**Application for Approval of Details Reserved by Condition  
Town and Country Planning Act 1990  
Planning (Listed Buildings and Conservation Areas) Act 1990**

**Discharge of details reserved by conditions 3 (perimeter boundary treatment), 10 (cycle parking) and 14 (highways specification) of previous Reserved Matters approval 2019/91638 for erection of 27 dwellings pursuant to outline permission 2017/92233 for erection of up to 34 dwellings**

**Land at Abbey Road, Shepley, Huddersfield, HD8 8DY**

**Application Number: 2024/92862**

Client:	Job No:	
Scottfield Ltd	18,019	
Project:		
Abbey Road, Shepley		
Title:		
Western Boundary and Plot 27 Wall Proposals		
Date:	Scale:	Checked by:
07/19/21	As indicated	BBA1
Drawing No:	Drawn By:	Revision:
00-111	MRC	B

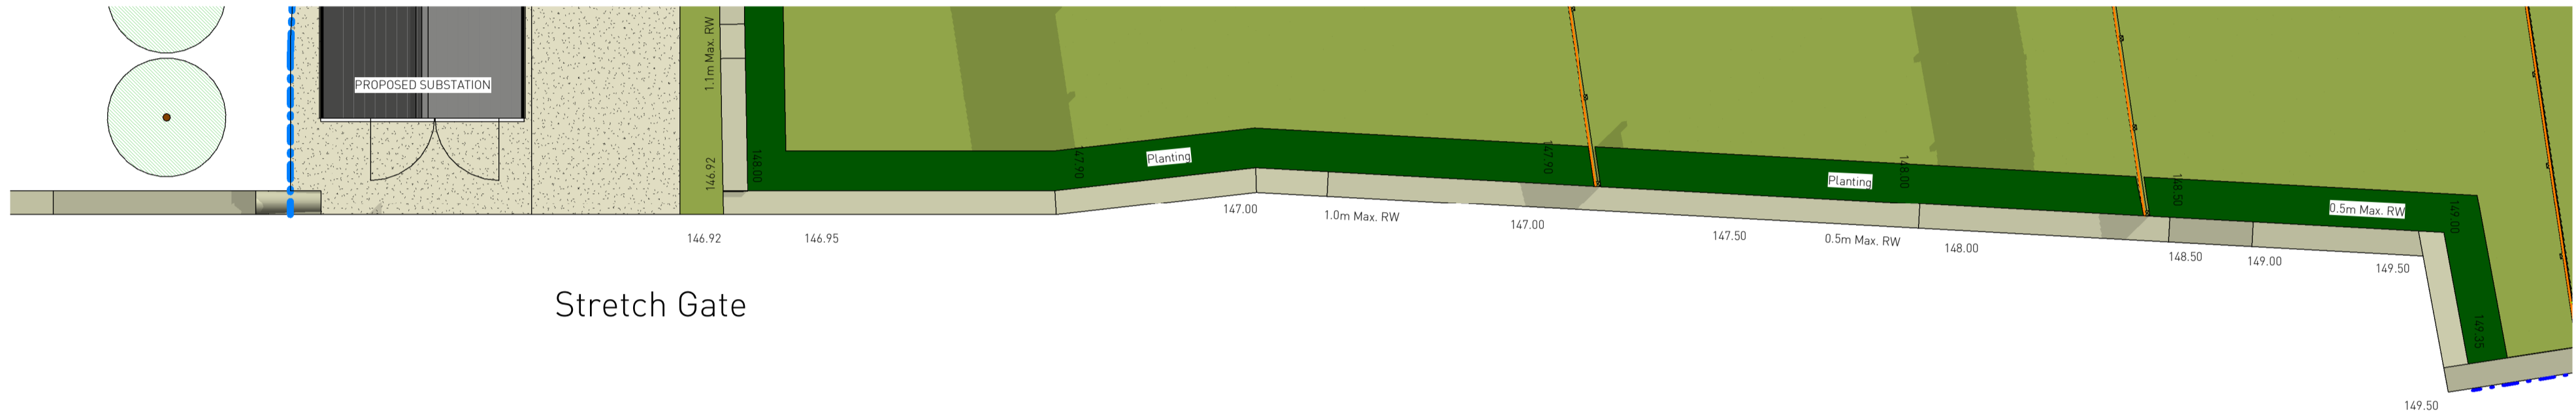
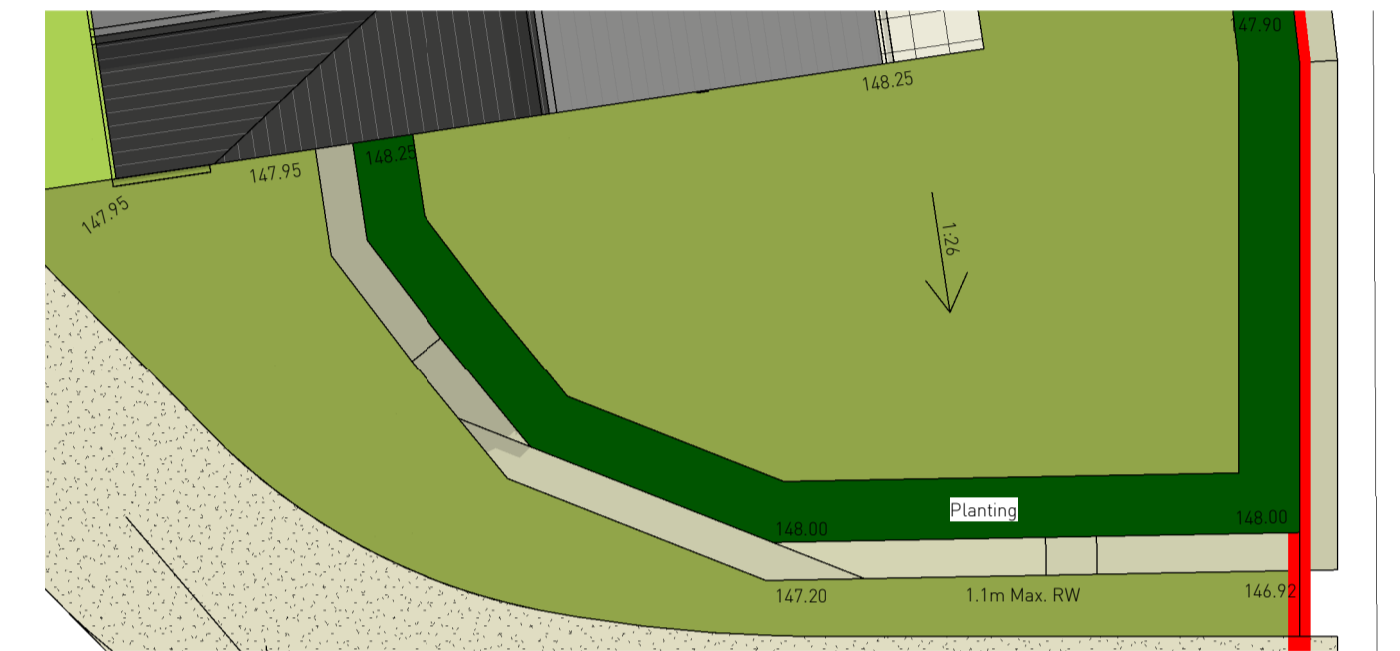
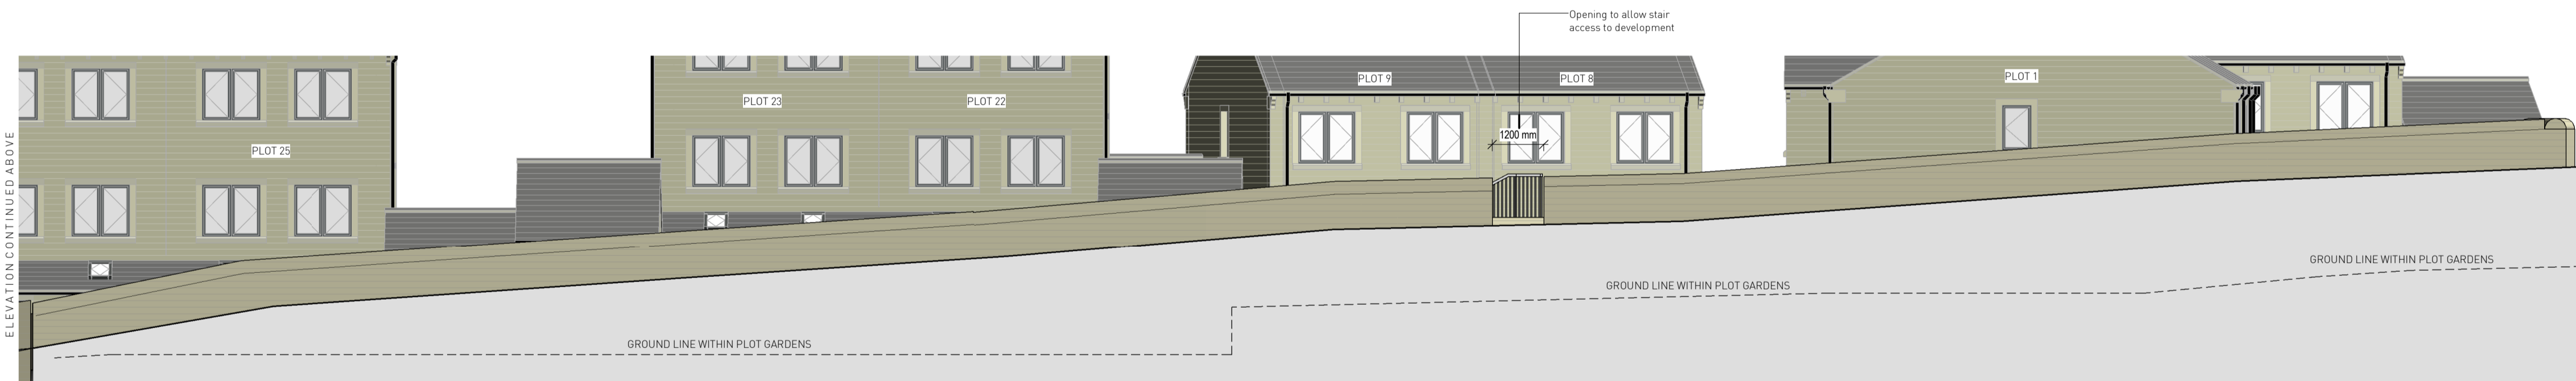
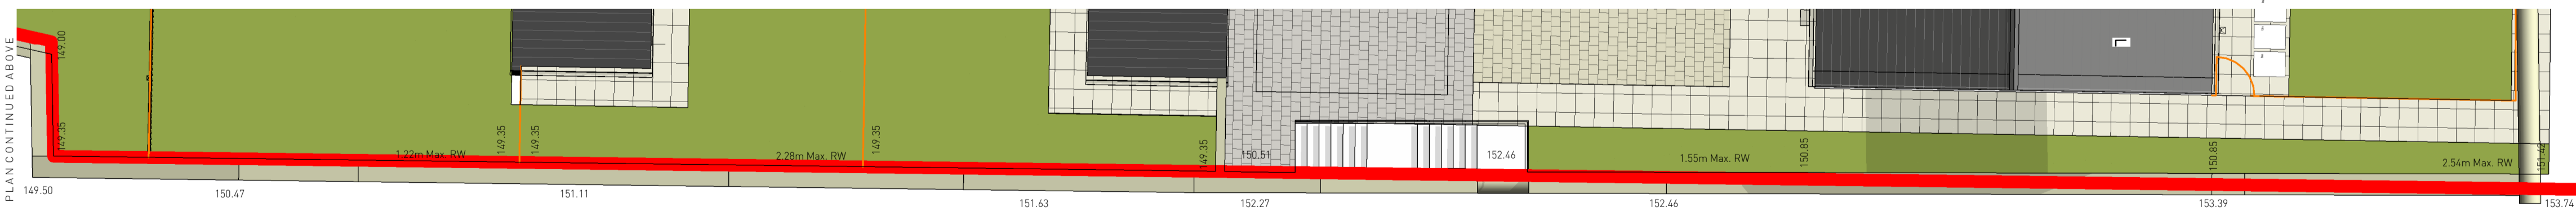
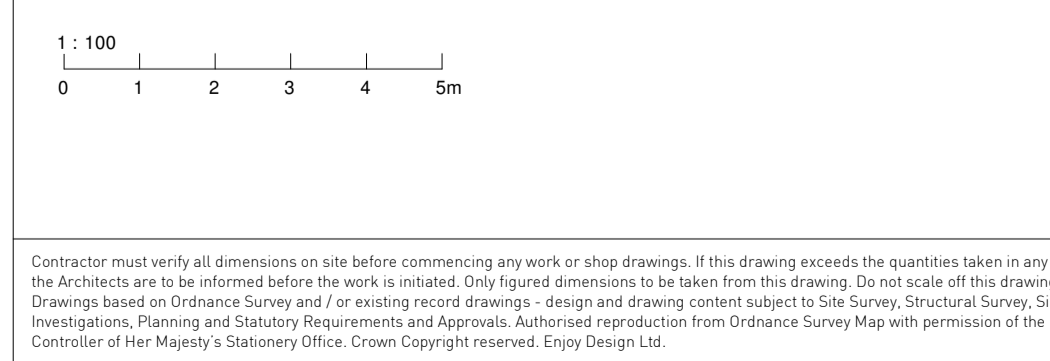
**Condition 3 (perimeter boundary treatment)** – You have submitted a drawing titled “Western Boundary and Plot 27 Wall Proposals” (drawing 00-111 rev B) pursuant to condition 3. This drawing (which had already been submitted and approved under application 2022/90245 in relation to the site’s western boundary and around the side of plot 27 (now 31 Tailors Green)) does not show boundary treatments for the rest of the site’s perimeter. Furthermore, you have not submitted an assessment of the works required to repair/replace the site’s existing stone perimeter wall, or a timescale for the implementation of the boundary treatment. This information is specifically required by condition 3.

It has not been demonstrated that highway safety, visual amenity and the character of the surrounding area would be maintained. As insufficient information has been submitted, an approval pursuant to condition 3 cannot be issued.

TITLE	
SECTION 38 LAYOUT	
PROJECT	
ABBEY ROAD NORTH, SHEPLEY	
CLIENT	
CAMSTEAD	
DRAWING STATUS	
FOR CONSTRUCTION	
Scale	Date
1:500 @ A1	APR 19
Drawn	Chk.
DJG	TC
Rev. No.	Rev.
1305/11/02.01	N

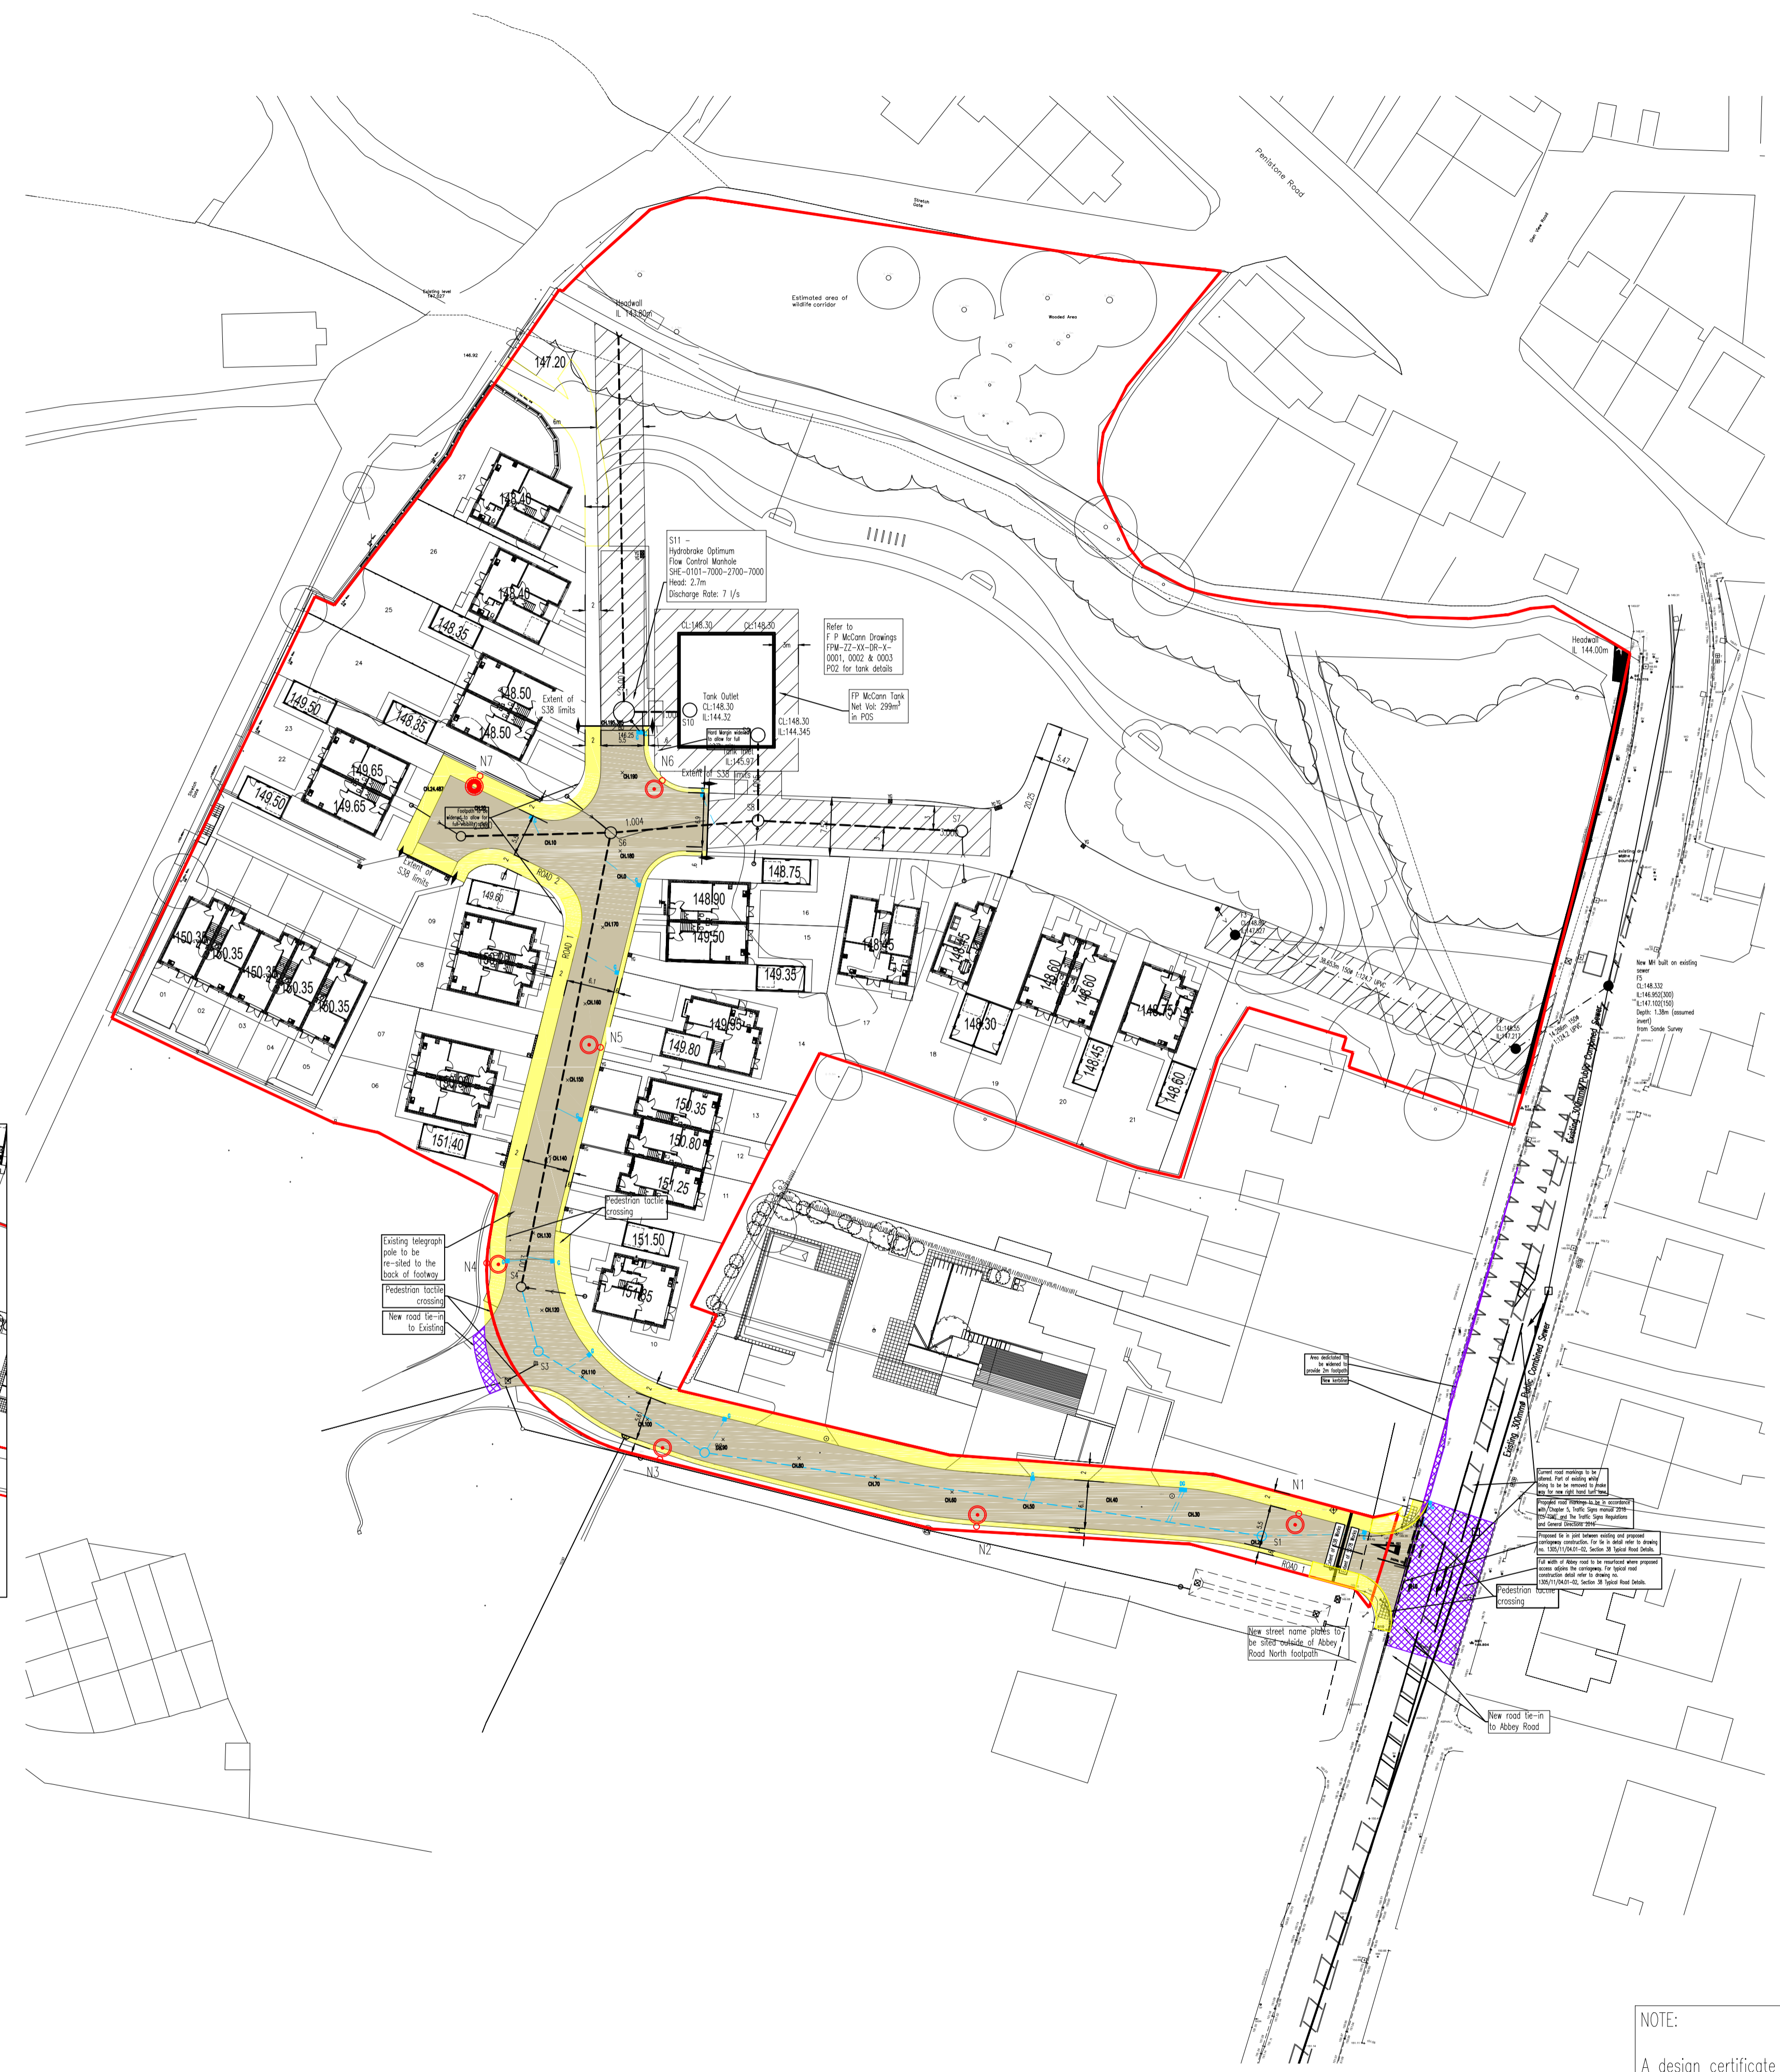
**Condition 14 (highways specification)** – You have submitted a Section 38 Layout (drawing 1305/11/02.01 rev N) pursuant to condition 14. While this provides a plan view of the proposed highway works (including locations of gullies etc), it does not provide a full specification (including sections, full details of drainage features and surface materials etc).

It has not been demonstrated that highway safety and safe pedestrian access to and from the site would be provided and maintained. As insufficient information has been submitted, an approval pursuant to condition 14 cannot be issued.
